RFS

State Significant Development - Industry

Request for comments - exhibited Environmental Impact Statement (EIS)

Glendenning Road Data Centre - 2 Glendenning Road Glendenning 2761, 2//DP1137162

**Figure 8: APZ Diagram Source: NearMap (2024) with overlays by BFCS P/L: Aerial Photography Date: 29/05/2024**

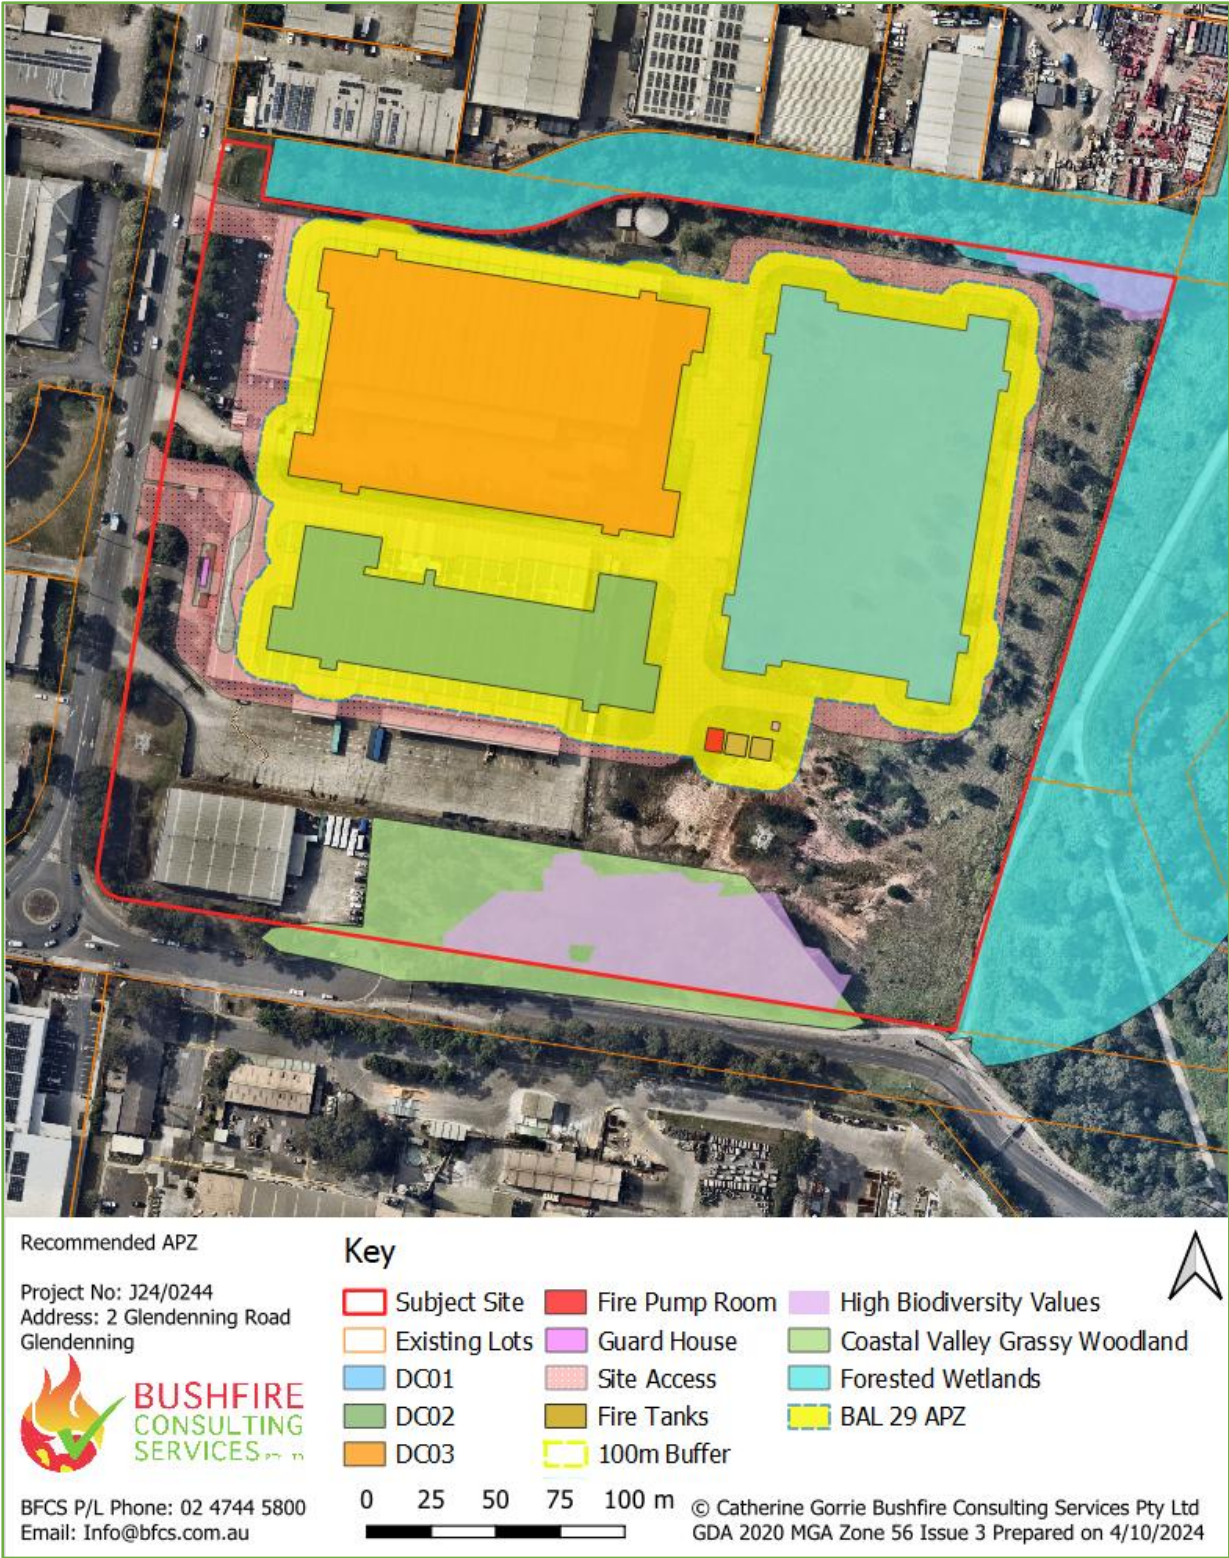
1. From the commencement of building works and in perpetuity, the entire property (except for the 'Biodiversity Zone' and 'Terrestrial Biodiversity' areas as shown on the site plan) must be managed to the standards of an inner protection area (IPA) as outlined in Appendix 4 of *Planning for Bush Fire Protection 2019*:
